**Subject: Front Entry Plan Revisions  
126-128 Danforth Street  
Portland, Maine**

Attached please find drawings revisions to the front entry to 126 & 128 Danforth Street. Design incorporates granite cheek wall redesign from 2" thick veneer panels & granite caps to solid 16" thick granite cheek wall blocks and structural foundation design.

BUILDING LOCATED AT
 126/128 DANFORTH STREET
 PORTLAND, MAINE
FRONT ENTRY REPAIR
 FOUNDATION PLAN, SECTIONS AND DETAILS

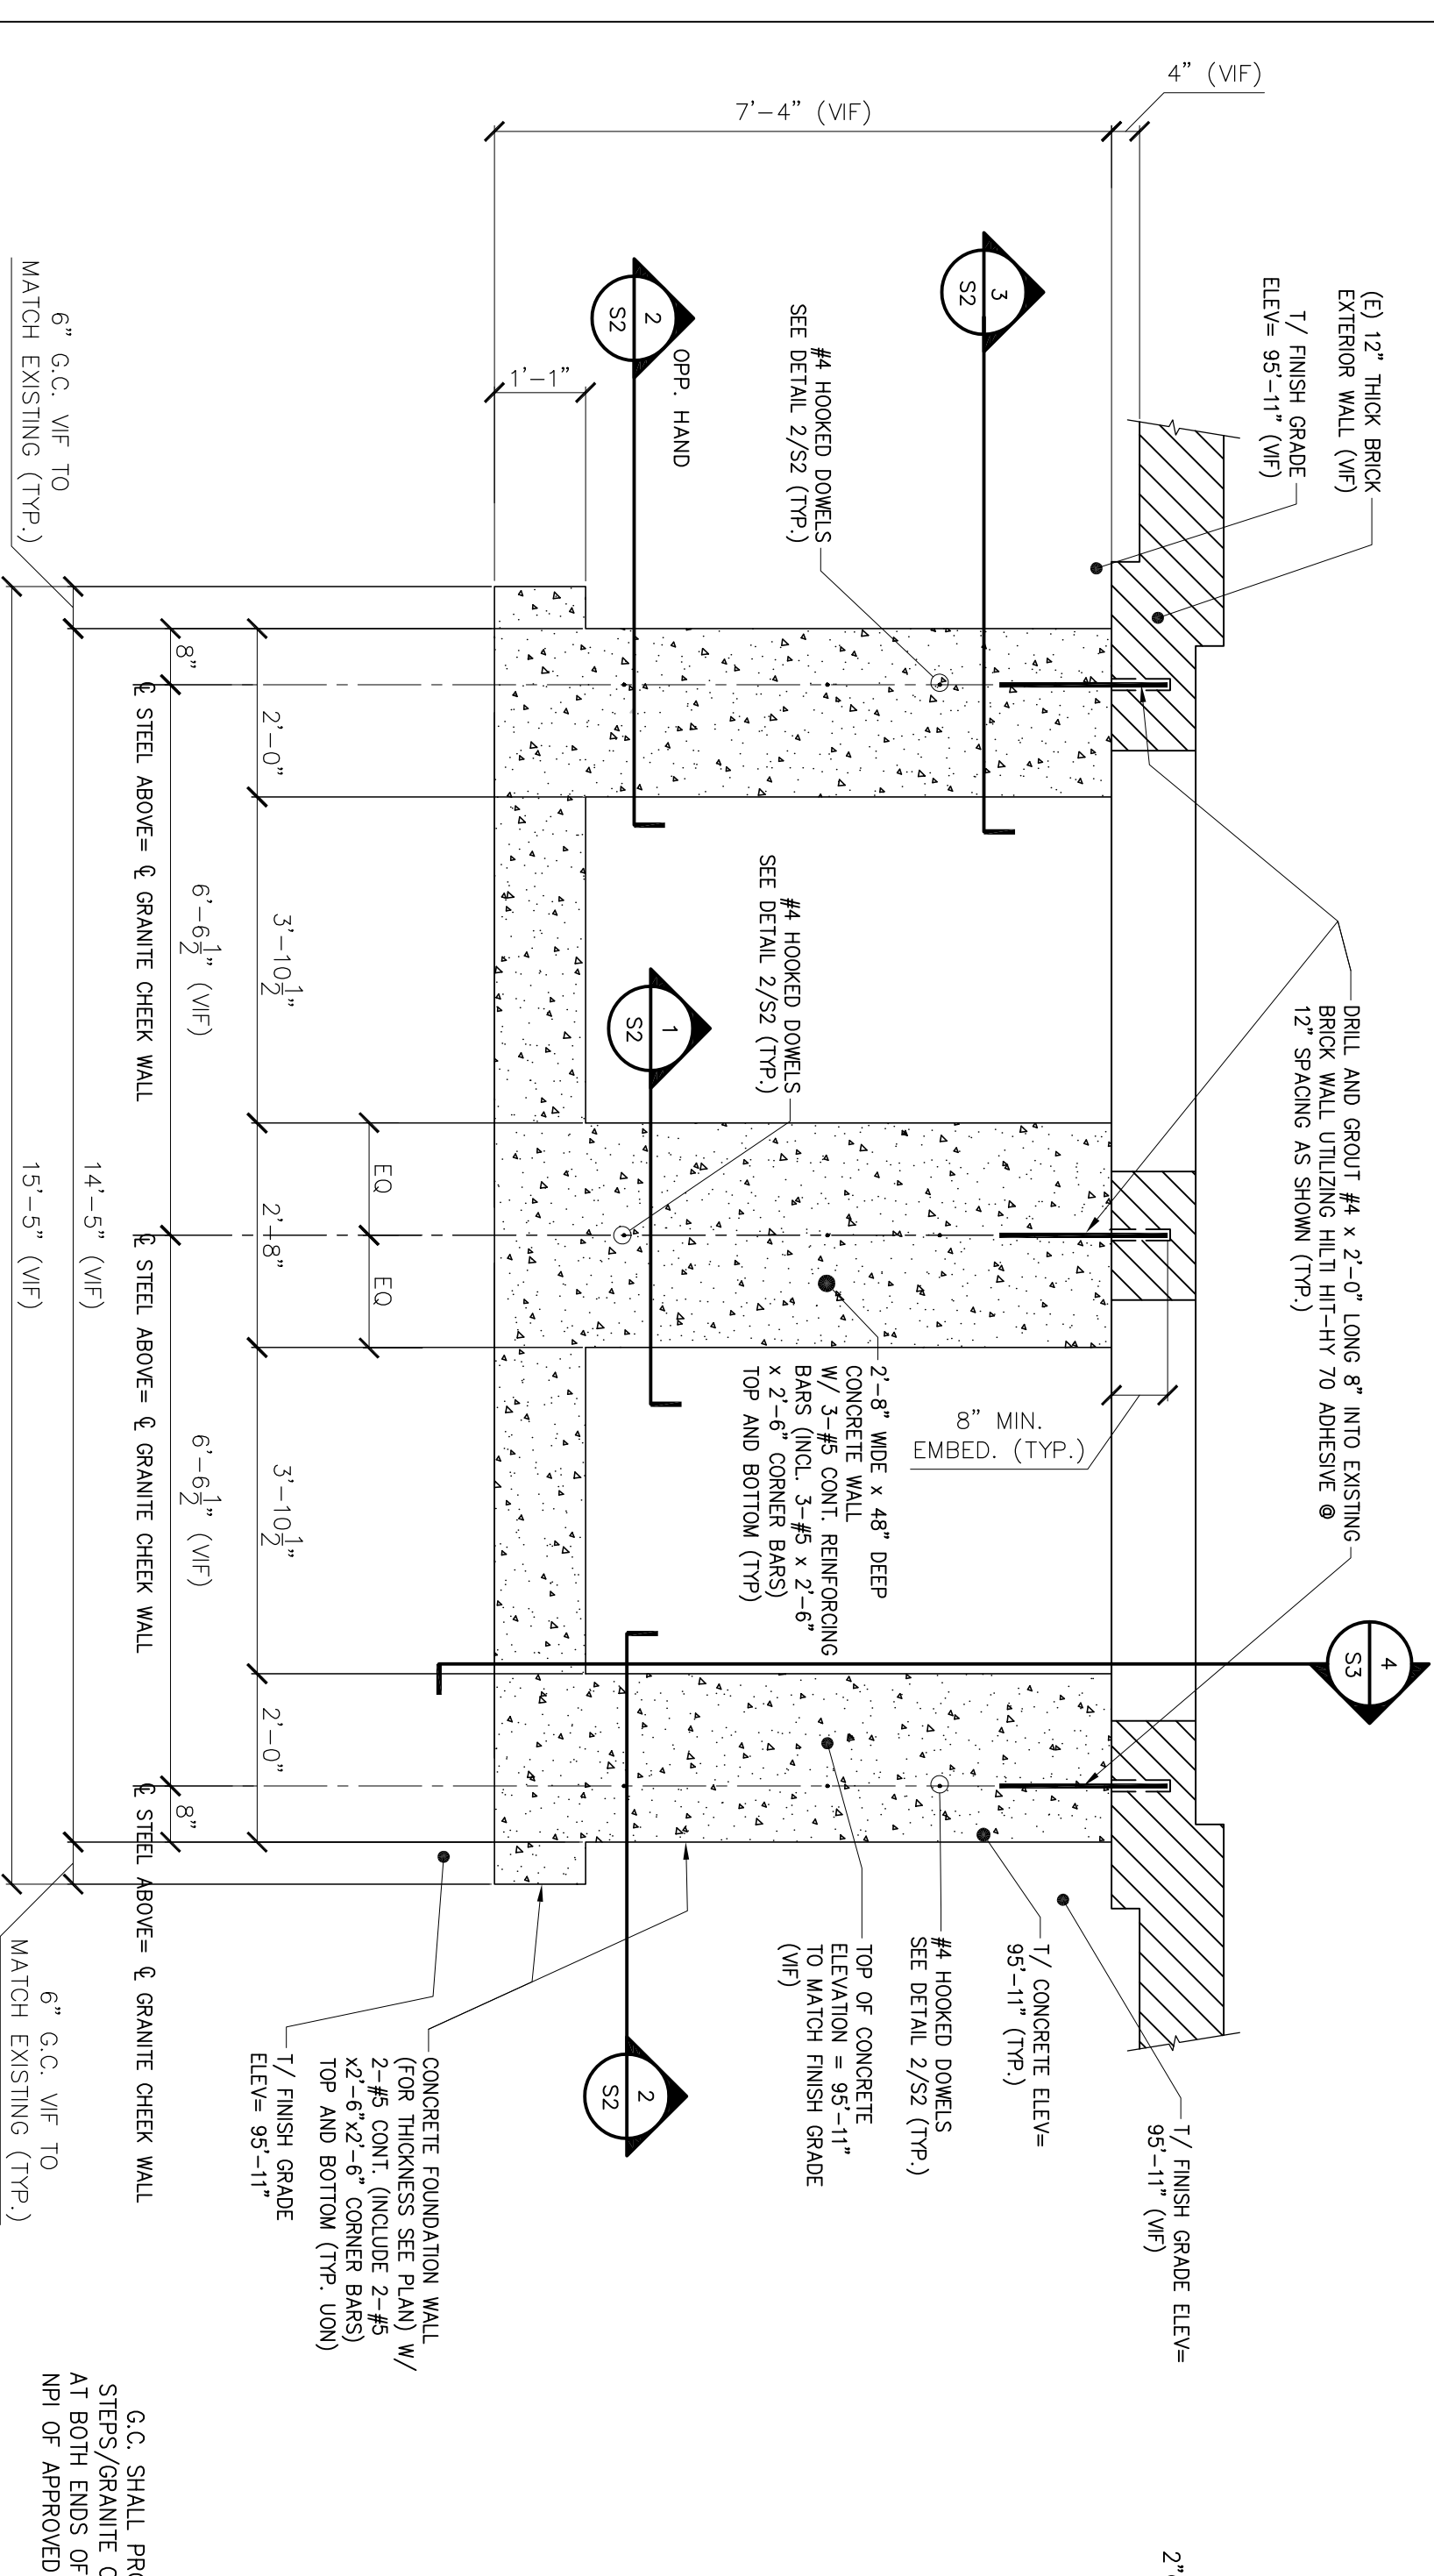
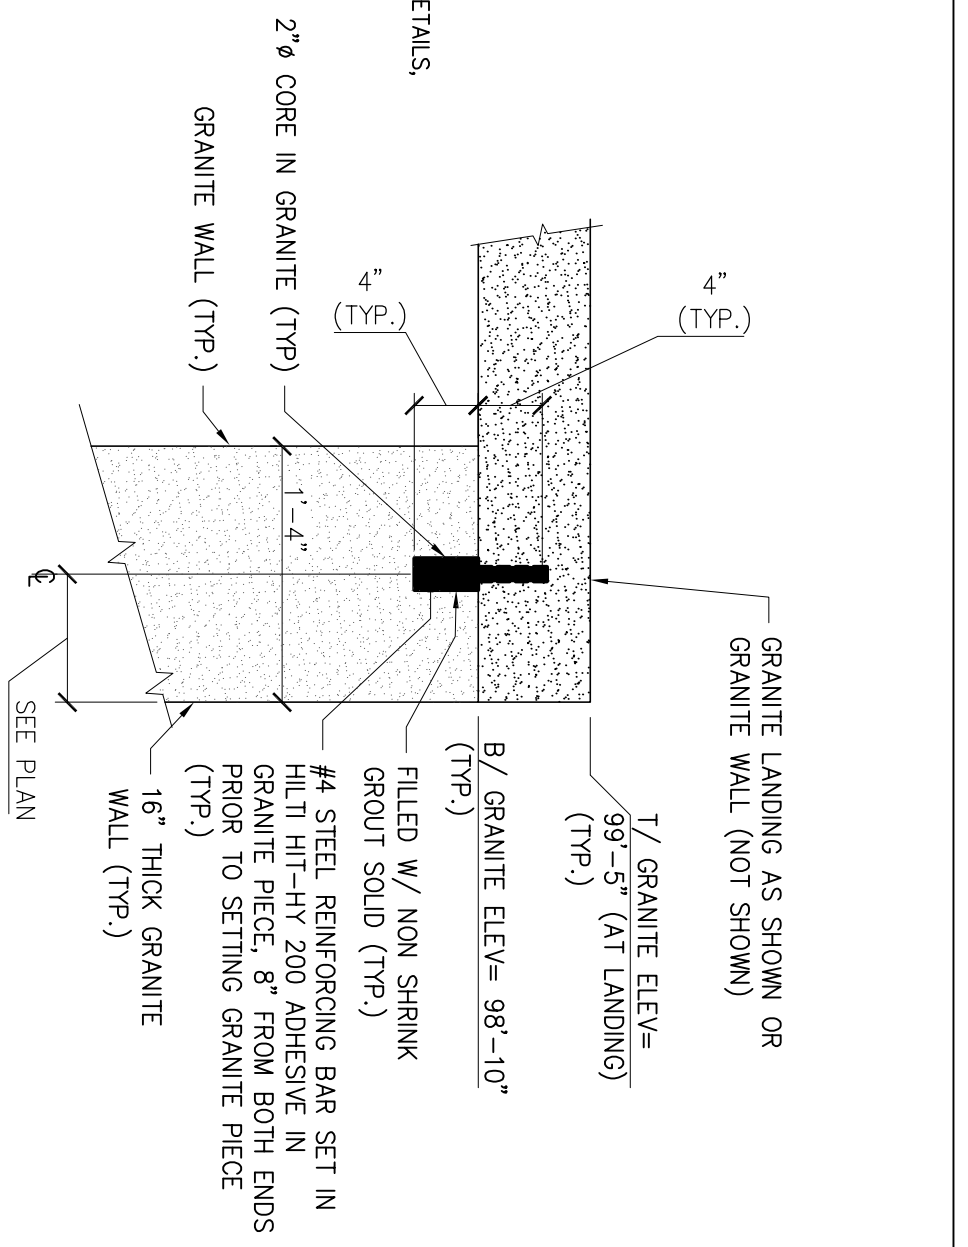
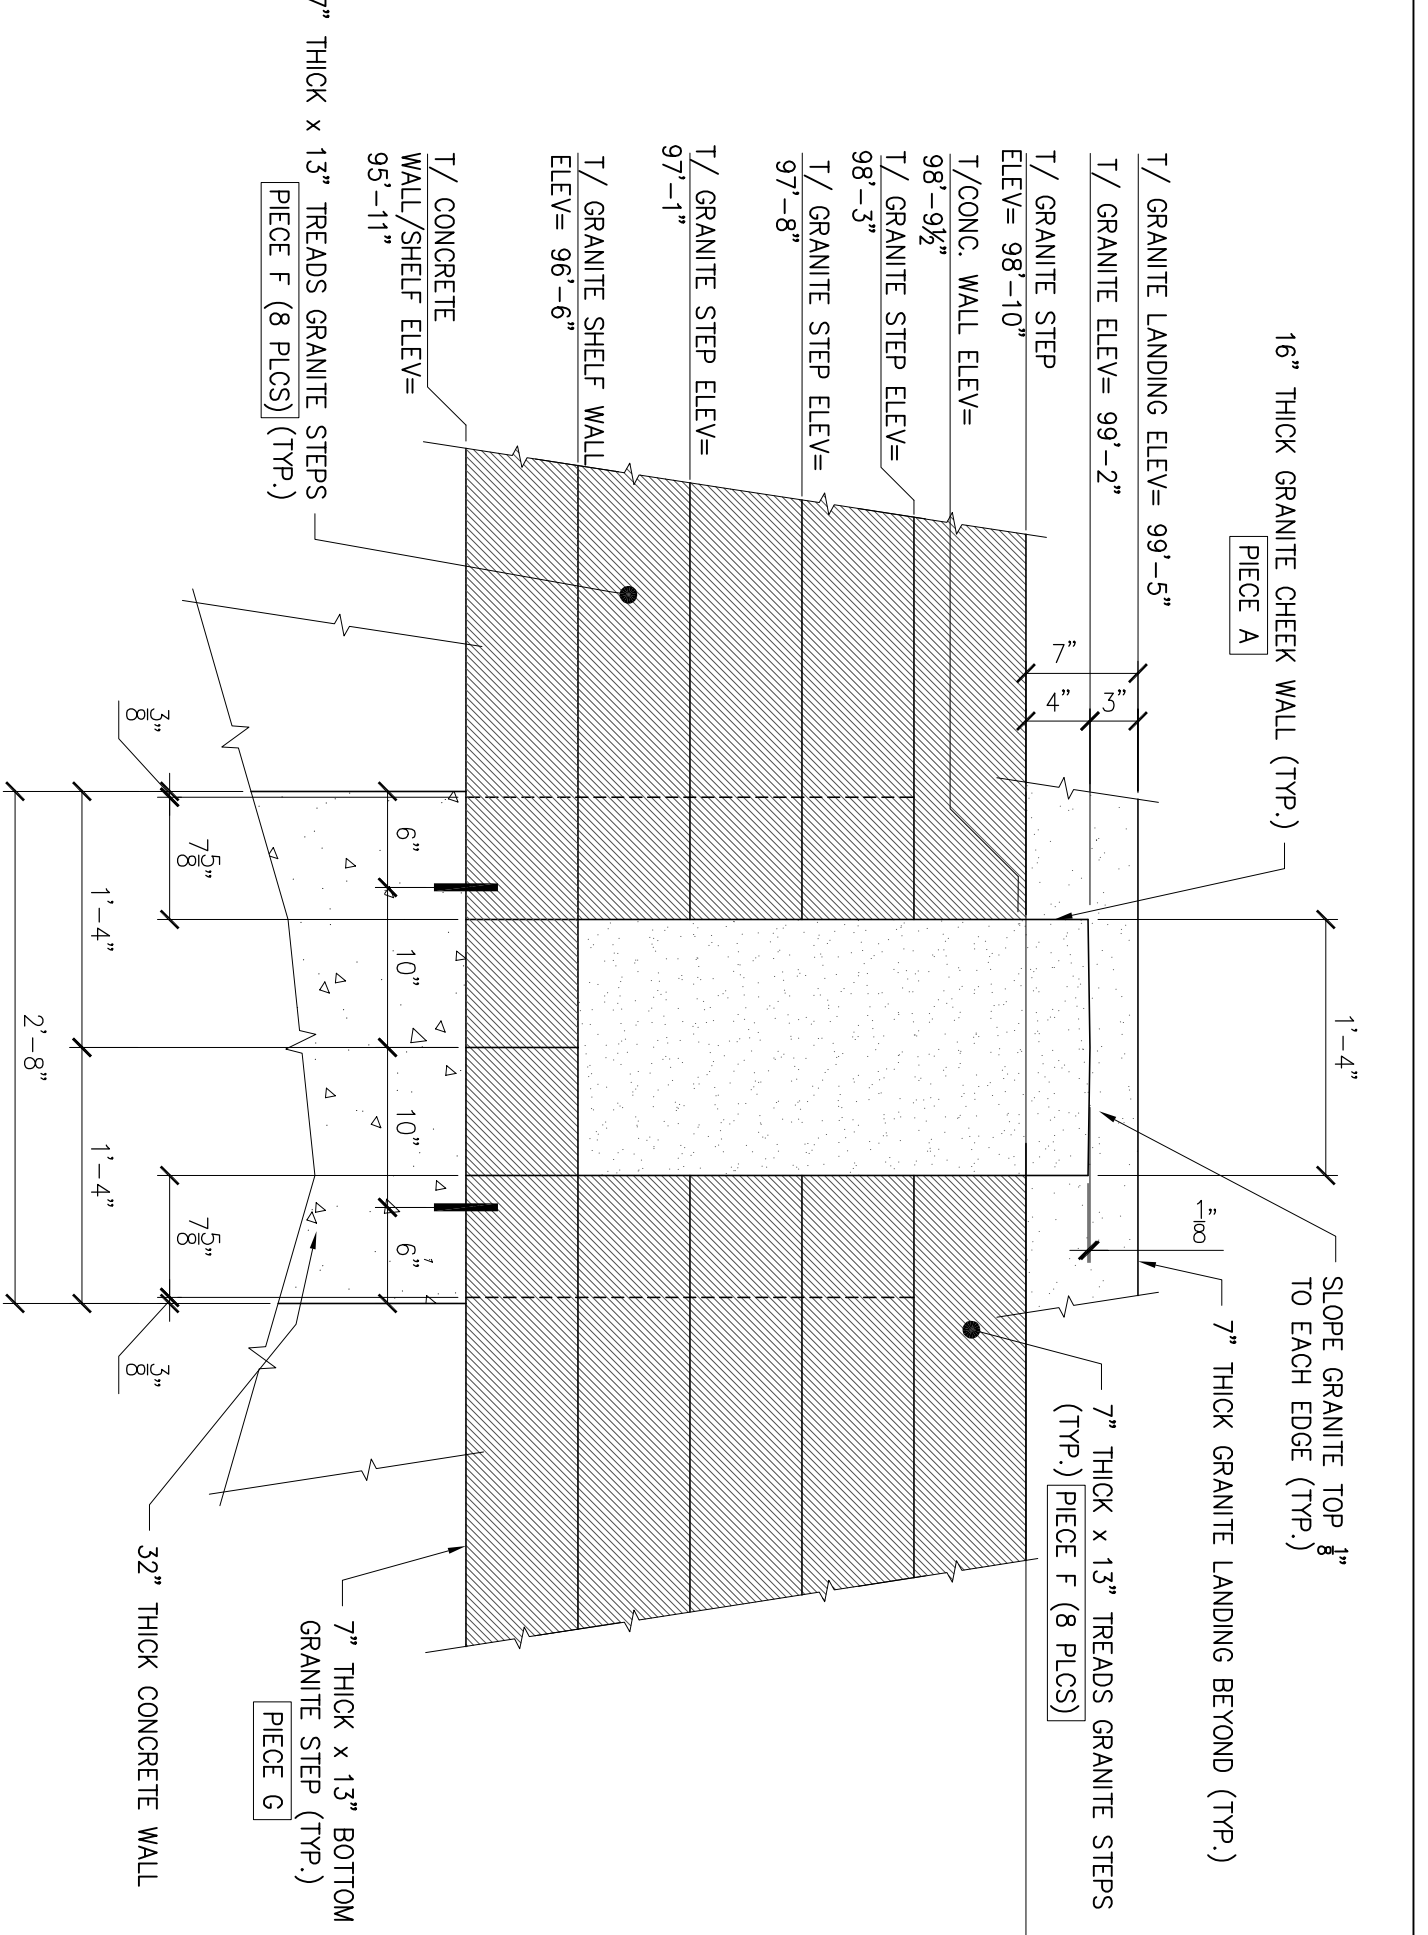
Drawings revised : **A2, A3, A5 and S1, S2, S3 and S5**
